Ric Lowe
Chartered Architect
Candid Architecture Ltd

Tree Update ref 2023/91002 Corby, Birkby Road, Huddersfield, HD2 2DR

Please find below and attached a response to the updated tennis court location and LPA tree consultee comments dated 14/8/23.

scale SHOWN@A3	date 29.09.23	drawn RL	revision B
drawing no. RG324 / BR01

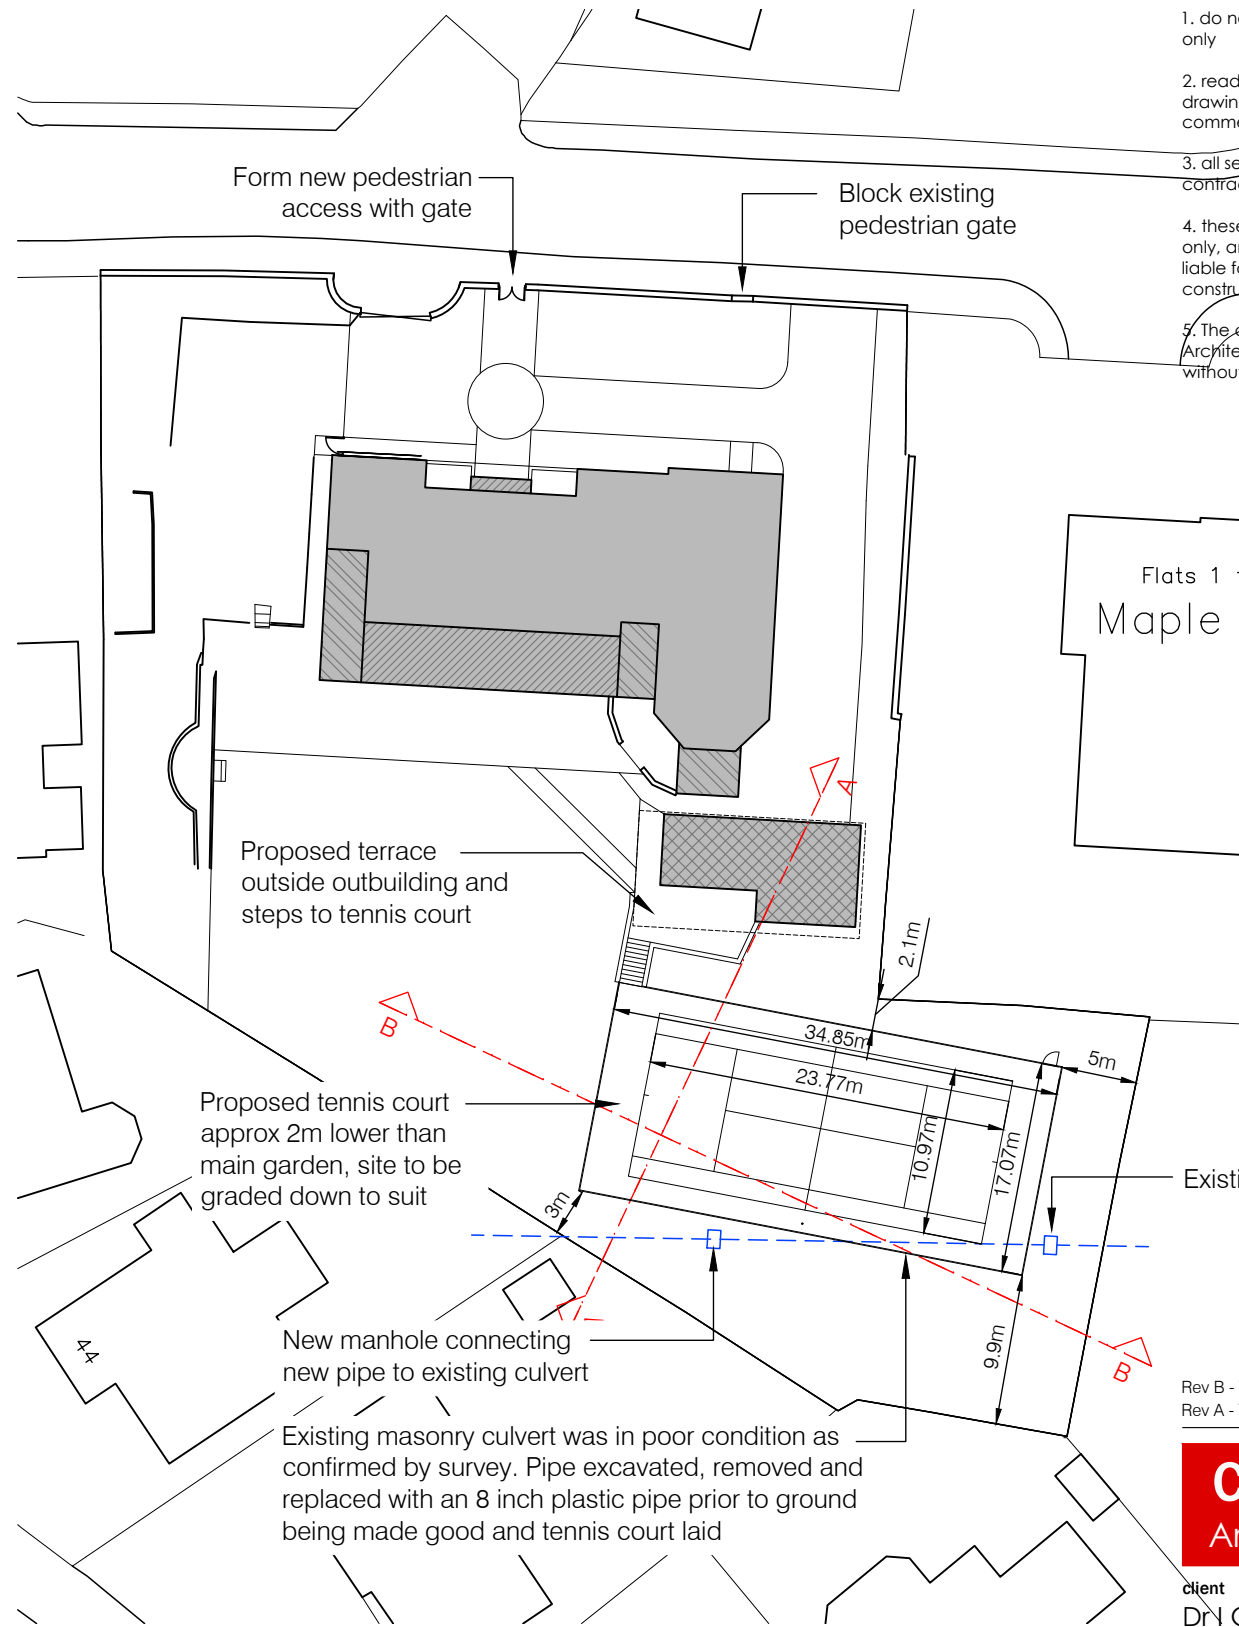
However, trees within/overhanging from properties on Inglewood Avenue that are subject to 17/85 haven't been surveyed or assessed. This is important as the construction and levelling required from the proposed tennis court could impact on the trees and vice-versa.

In order to progress this proposal, we would need to see an arboricultural impact assessment to help understand the impact this proposal could have on existing trees and an arboricultural method statement to show how this work can be done without causing harm to trees or their roots.

See second paragraph above and notes/photographs on attached plan

Proposed Site Plan - 1:200

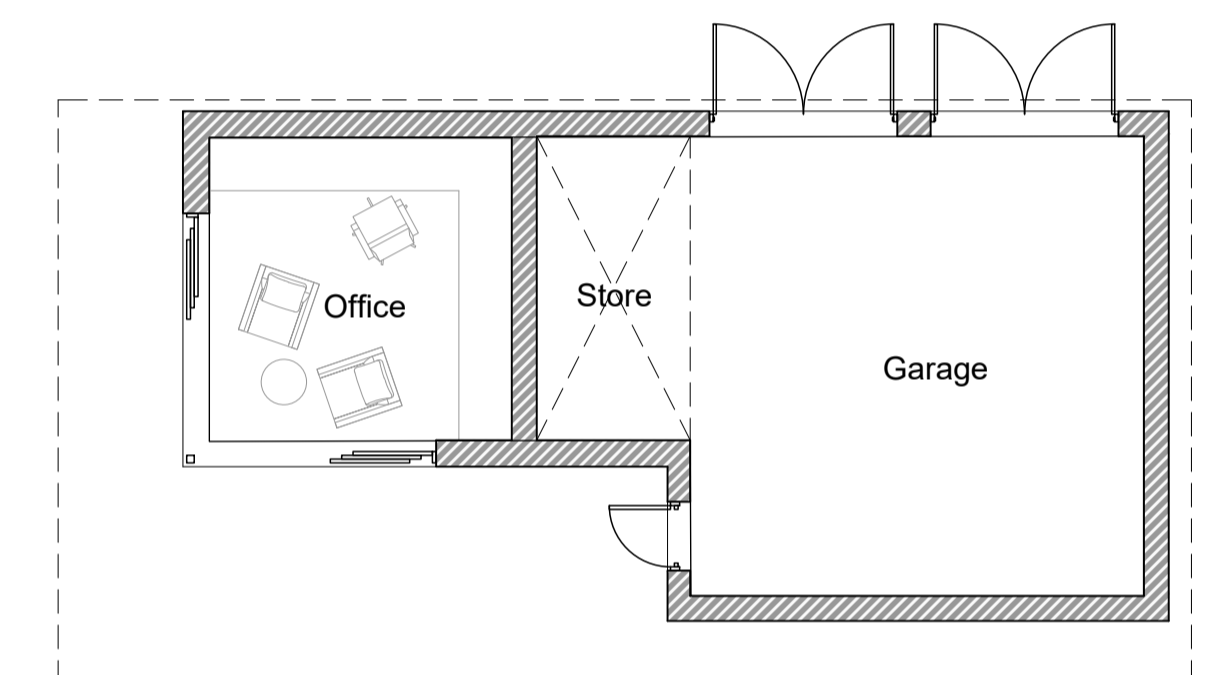
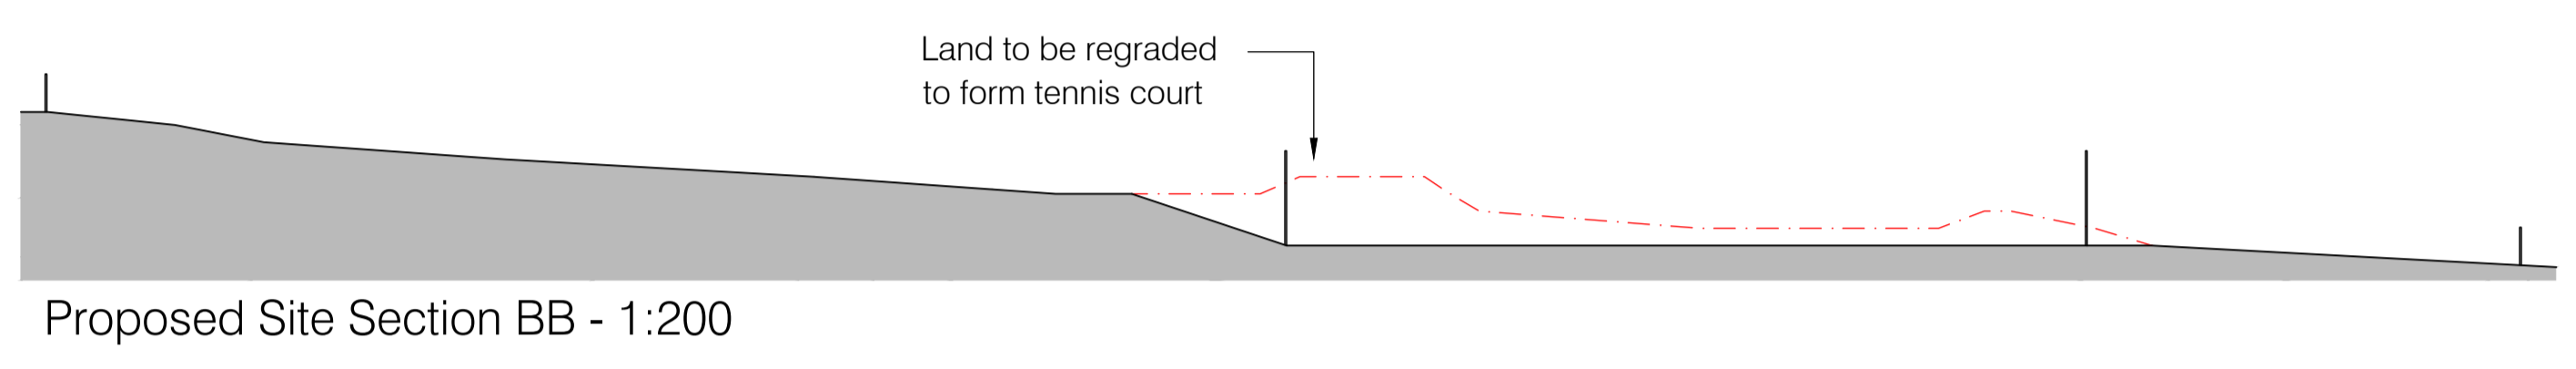
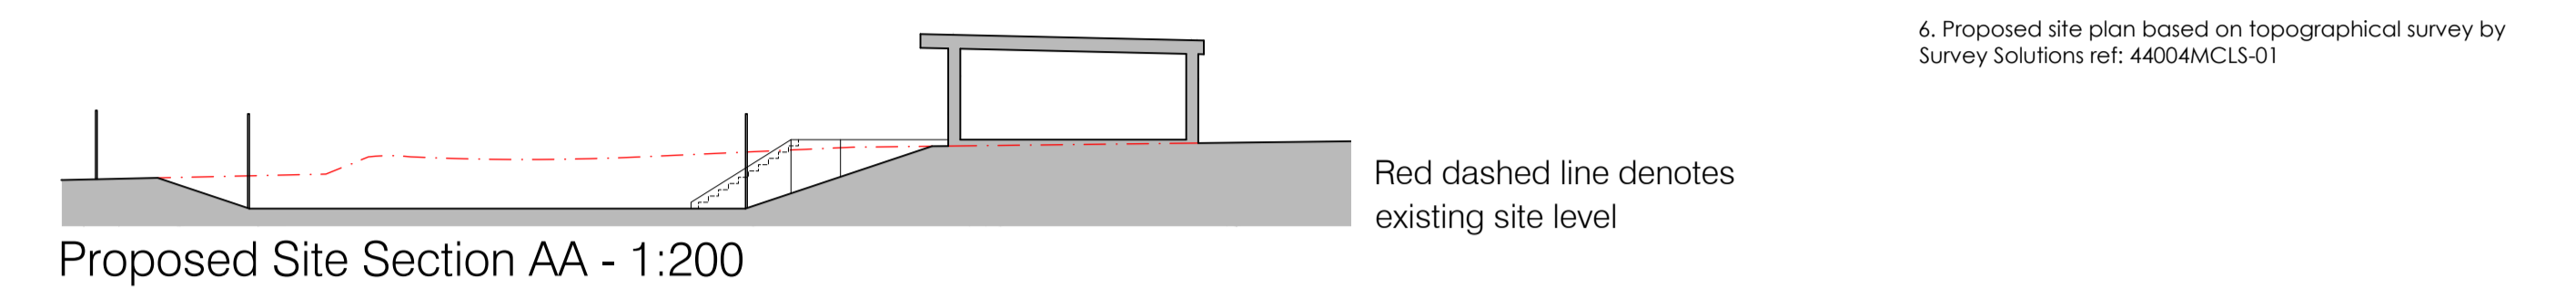
The garage being moved to along this boundary will foreseeably mean the increase of cars and vehicles etc. being parked along this boundary and under the canopies of the trees.

This could lead to increase pressure to prune the trees in order to reduce nuisance like honeydew, bird droppings and seasonal debris affecting them while parked.

Area was already used for car parking/vehicle access to rear, historic/recent pruning requests approved by LPA mean there will be no need to reasonably request pruning for many years.

Garaged vehicles will prevent/reduce the nuisance as listed. LPA has now stated their opinion and should further applications for pruning be submitted there is a planning record for them to refuse unnecessary works. As such the LPA has retained control over these trees.
